AMENDED PLAN
Ref. <u>A1</u>

**Proposal for new restaurant for Jack's Fish Bar (Use Class A3)
on land adjacent to Fulney Hall and Springfield's, Camelgate, Spalding, PE12 6ES**

Amendment: Amendments to design and parking area (dwg. nos.
1886-03C, 1886-05B and 1886-06B)

Drw Title: 3D Views & Sections

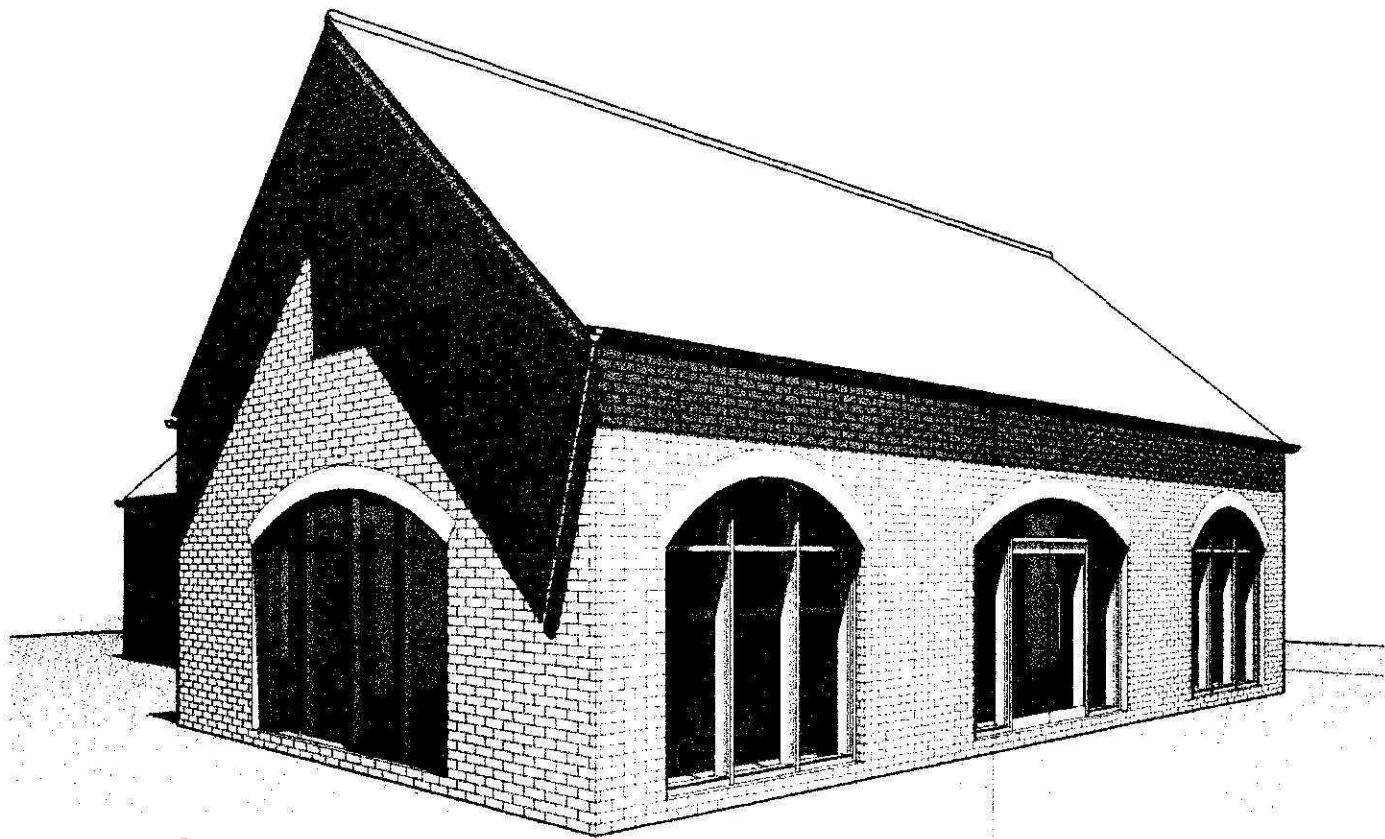
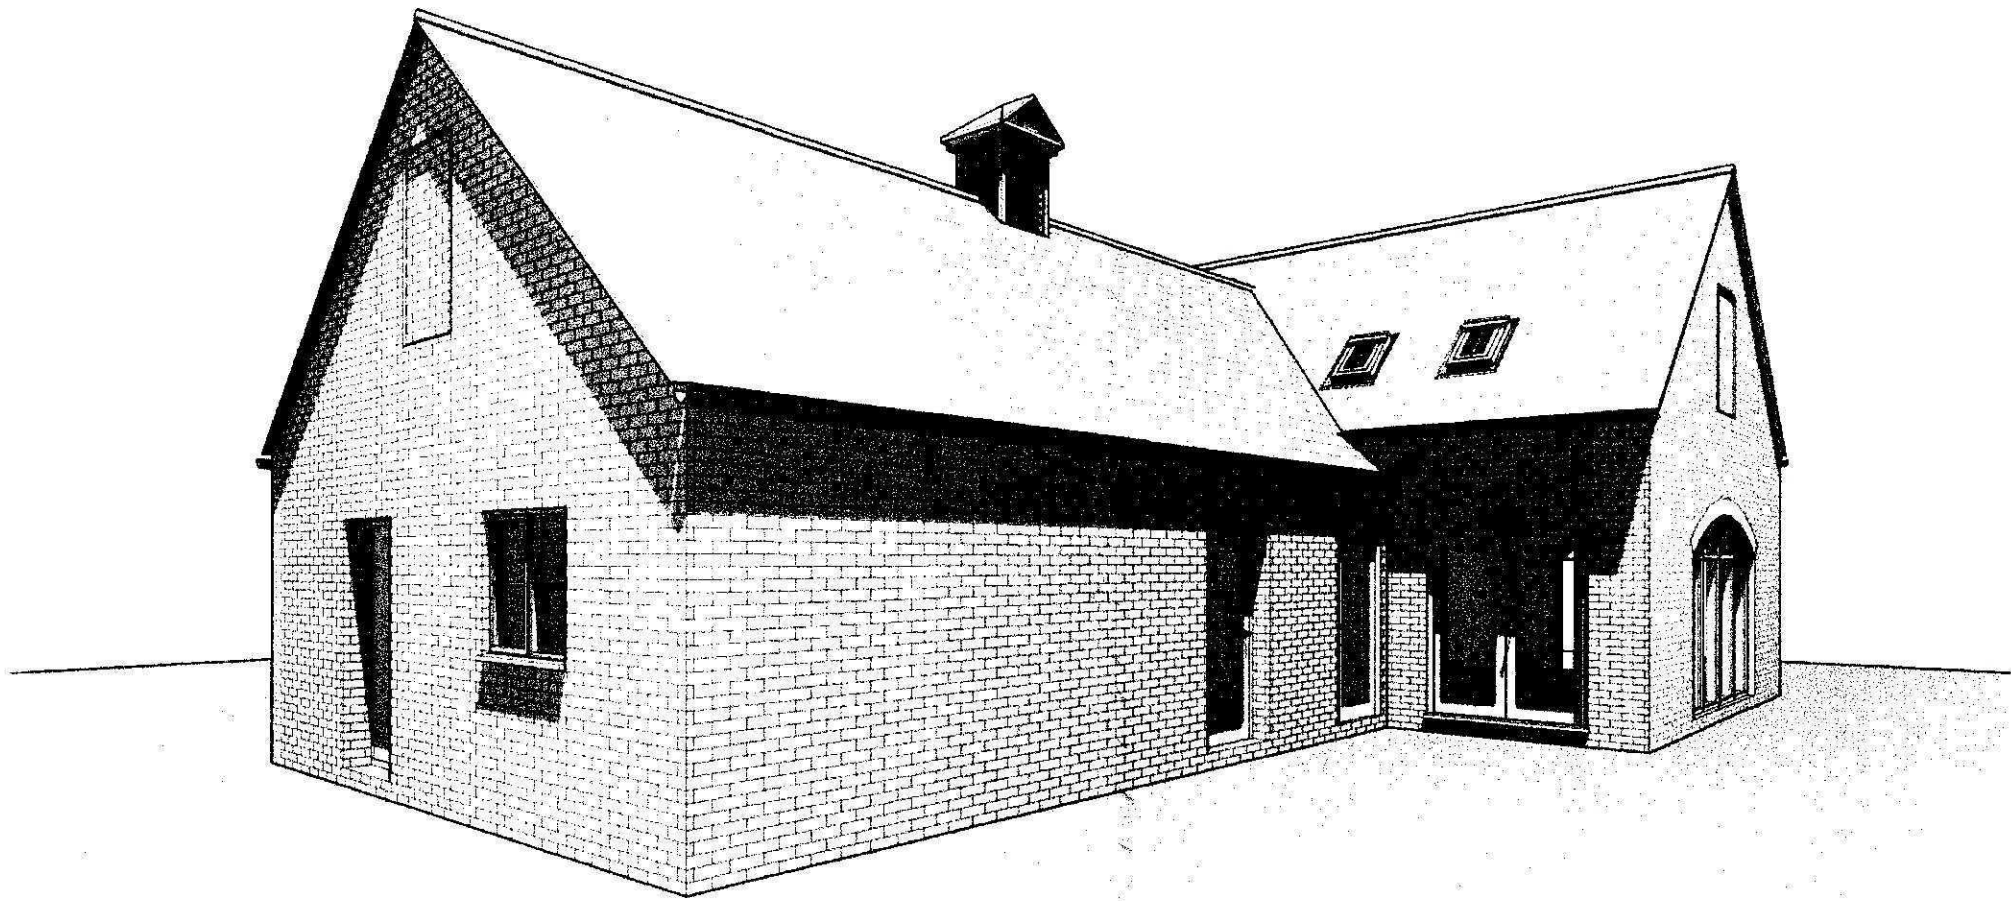
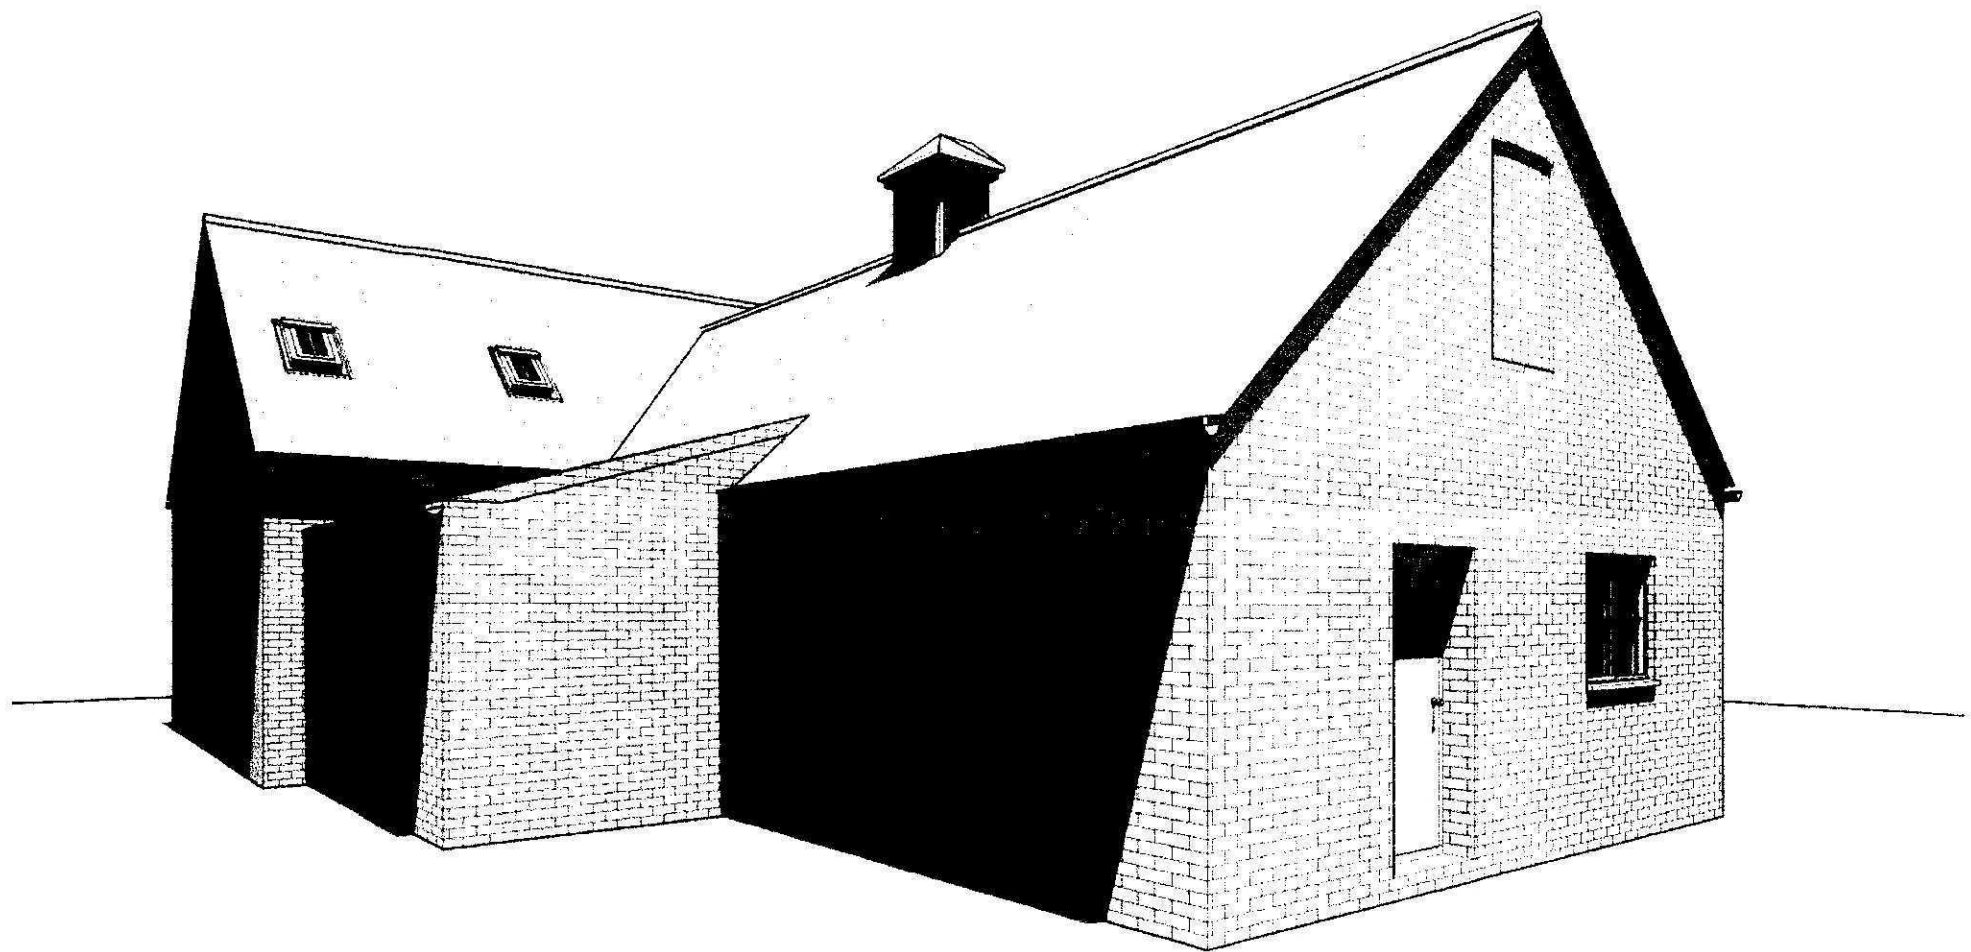
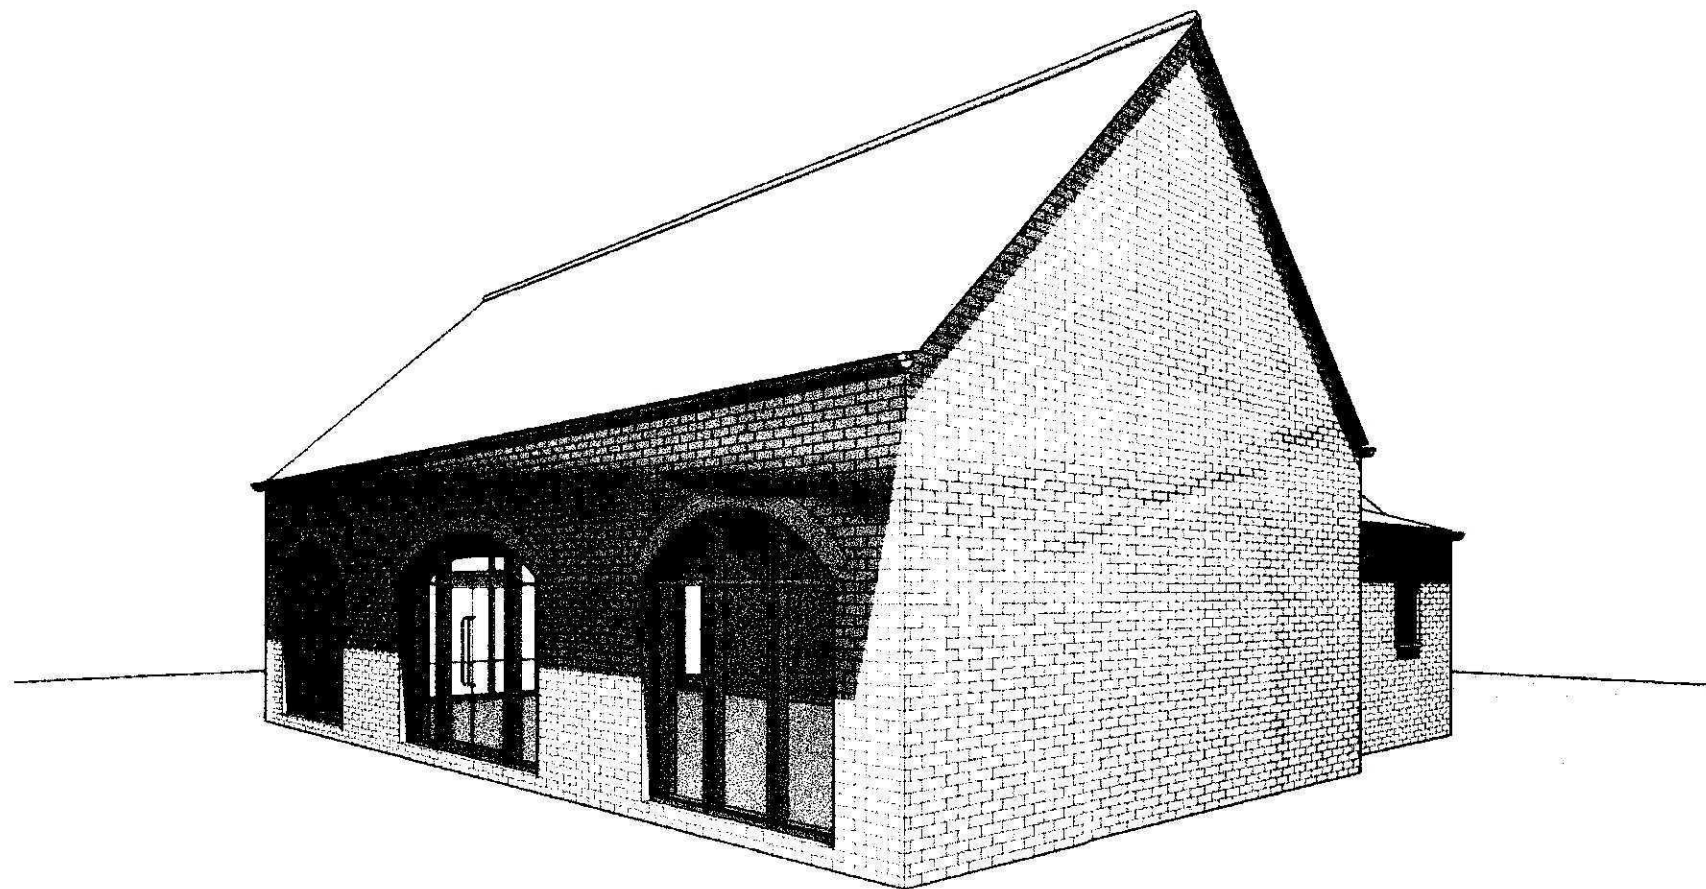
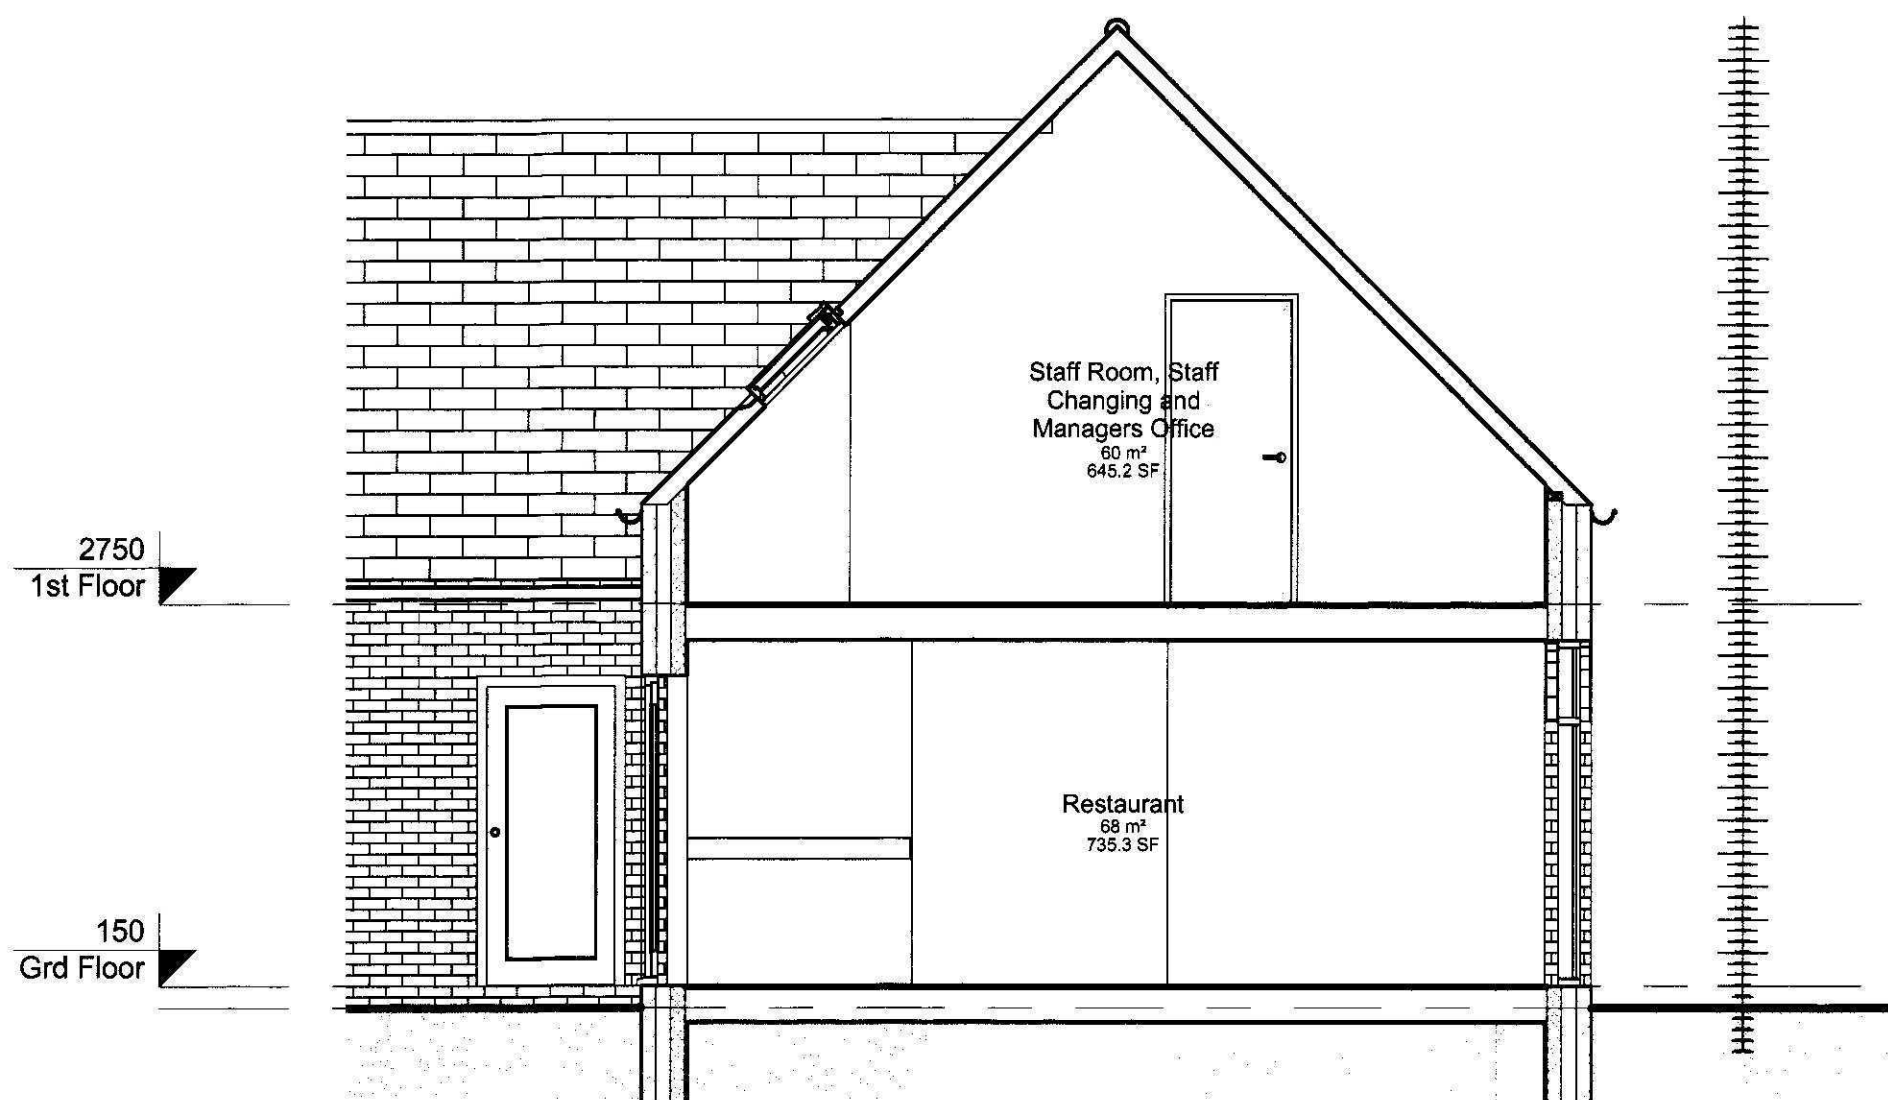
Revised plans show the location of the ventilation and extraction flue. The point of extraction will be in a louvered feature positioned on the rear roof ridge. The precise design and specification for odour management, flue dimensions, its filters and air changes will be dependent on the kitchen design, and this is not yet confirmed. It is a normal expectation for such specification details to be covered by planning conditions.
